Our ref: DOC21/683284-3  
Your ref: SSI-12590060

**Advice on RTS – State Significant Infrastructure – Hunter Power Project (Kurri Kurri Power Station) (SSI-12590060)**

Our ref: DOC21/680571-5

**Response to Submissions Report – Hunter Power Project (Kurri Kurri Power Station) (SSI-12590060)**

A typical design for a sediment basin is provided in Figure 5.2. The final sediment basin design would be confirmed during detailed design.

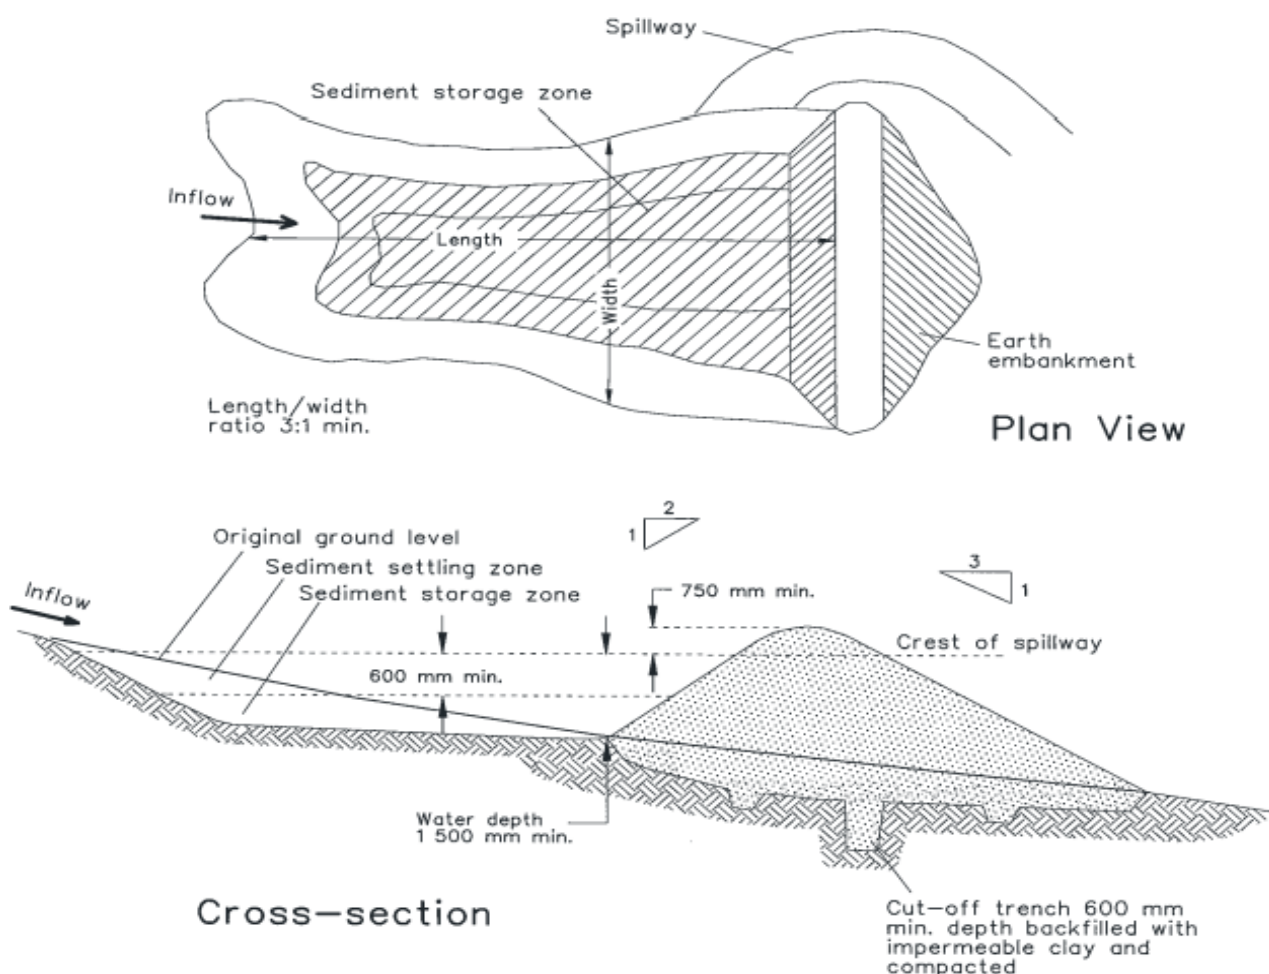
### 3. Erosion and Sediment controls proposed require significant site disturbance

The site is primarily a brownfield site with minimal additional earthworks or clearing required for development. Plant and equipment will be founded on piers and it is likely that the impact of this degree of earth disturbance can be managed on site without extensive sediment basins. It is noted that construction is proposed to be over a two-year time frame. The proposed sediment basin appears to have been sized for disturbance of the entire site with no mitigation measures or staging of site disturbance.

Access by plant and equipment during construction will disturb existing surfaces and may result in generation of sediment laden runoff. This can be better managed through stabilisation of access roadways, alternative lower-impact sediment control measures and potentially by installation of primary road base layers earlier in the construction process to minimise sediment generation.

The largest bulk earth works appear to be for the sediment basin which is intended post construction be converted into combined on site detention and pollution control pond.

Detailed design should consider fit for purpose erosion control measures which do not require a sediment control basin excavated below the water table.

- Proposal Site
 Asset protection zone
 Detention basin
 Sealed roadway
 Crushed rock
 Landscaping
 Grass / Road base
 Existing waterbodies
 Existing cadastre
1 Proposed Switchyard Area
2 Proposed Plant Area
3 Proposed Buffer Area

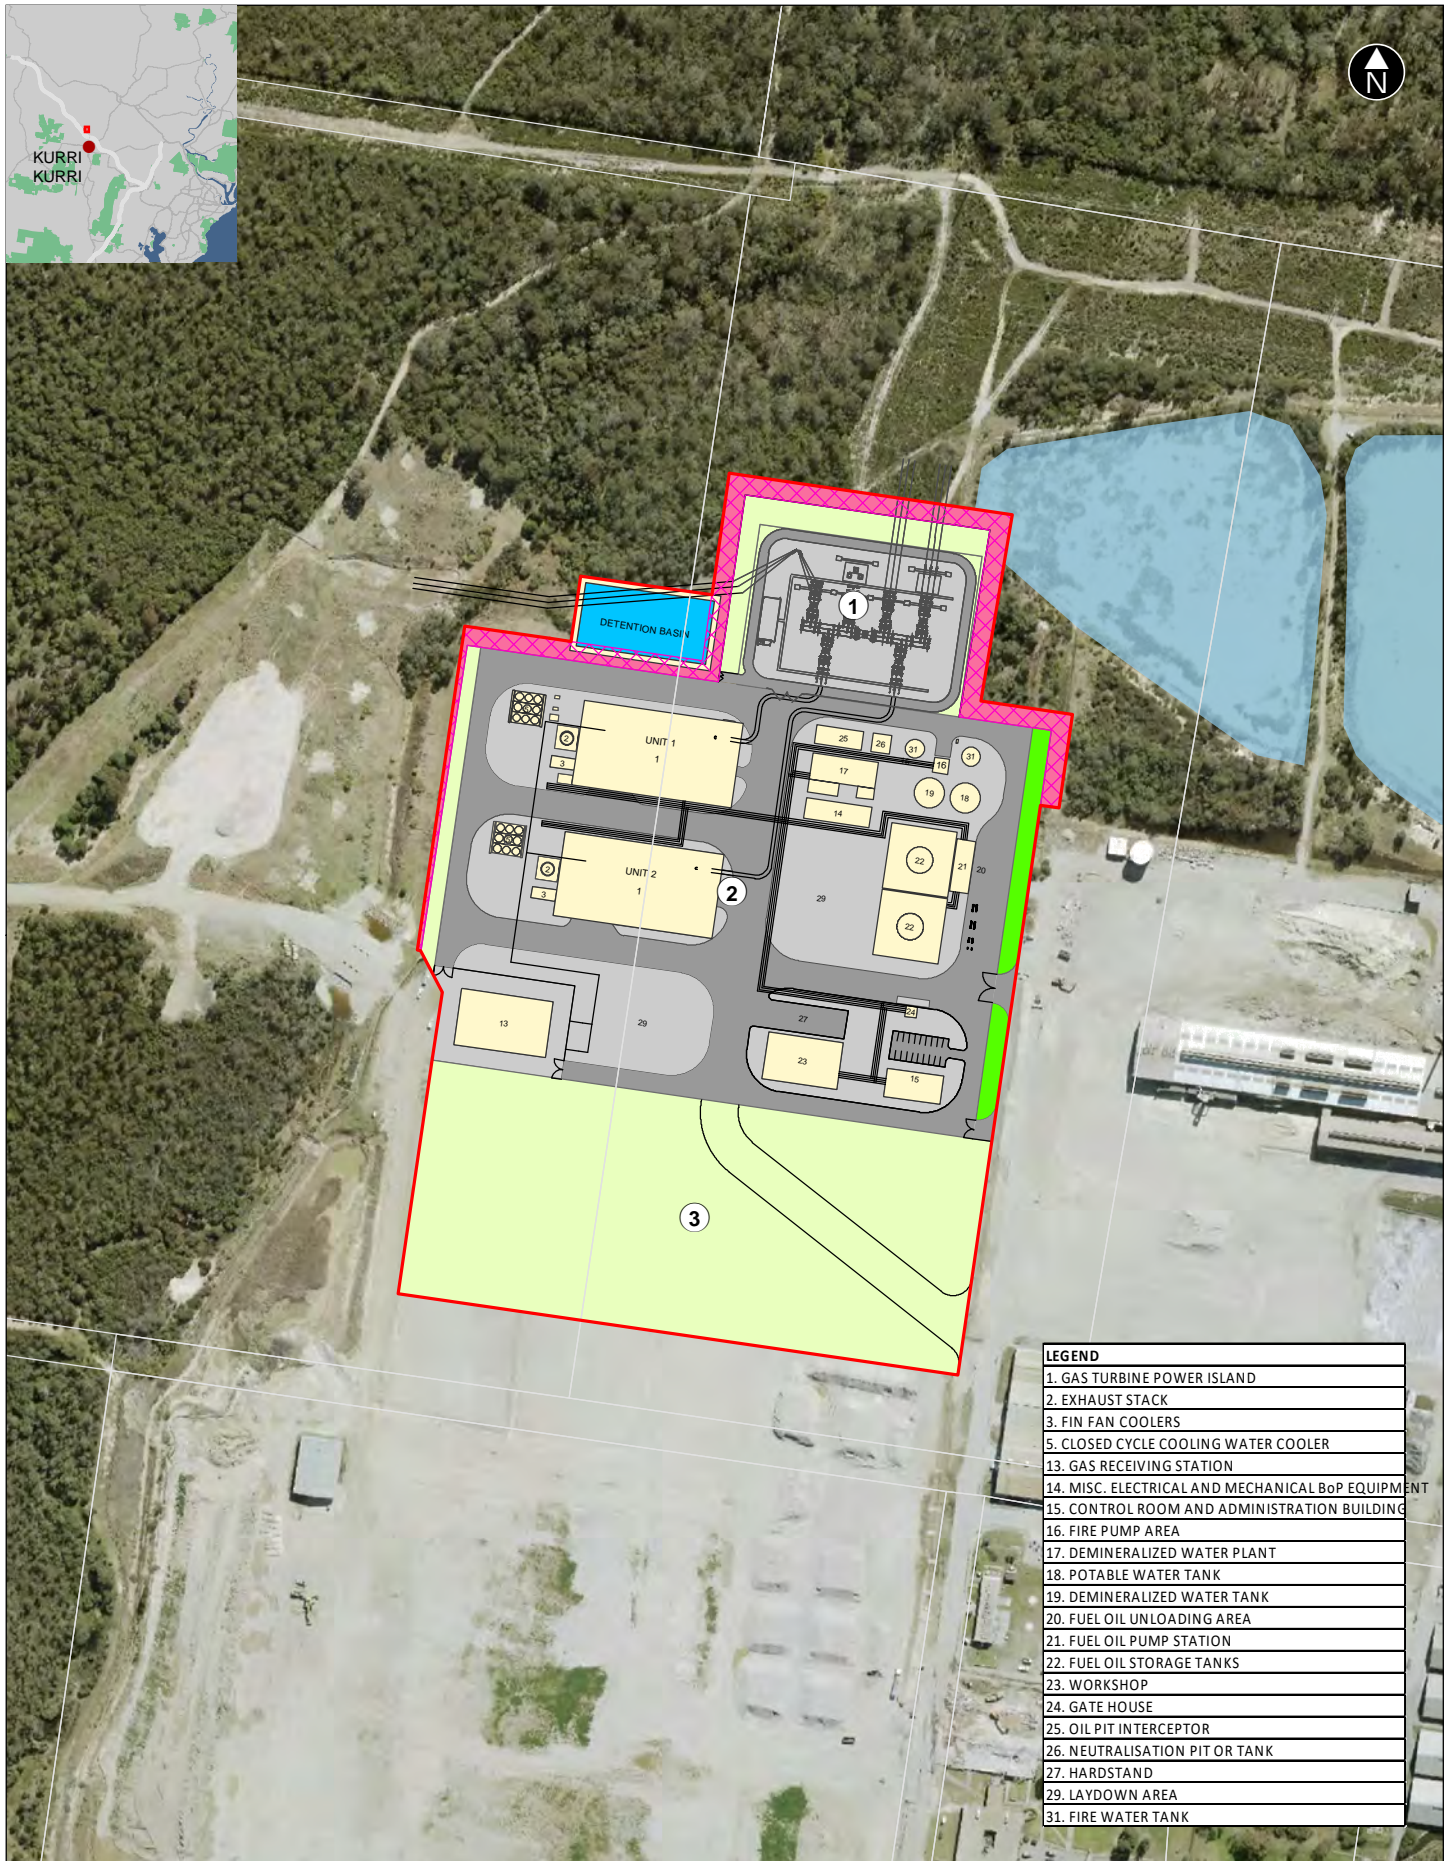
The pollution control modelling has been updated to include revised impervious areas which are now consistent with the hydrology report. Figure 3.1 of the response includes proposed surface treatments which include sealed roadway, crushed rock, asset protection zones, landscaping and areas labelled as grass/road base. It is unclear what surface finish will occur in the asset protection zone and the grass/road base area will behave differently if it is grass rather than road base.

Detailed design of pollution controls should consider removing the proposed open pond and using a treatment train approach suitable for the likely pollutants which would be generated by this development. Management of spills and road runoff will be key requirements.
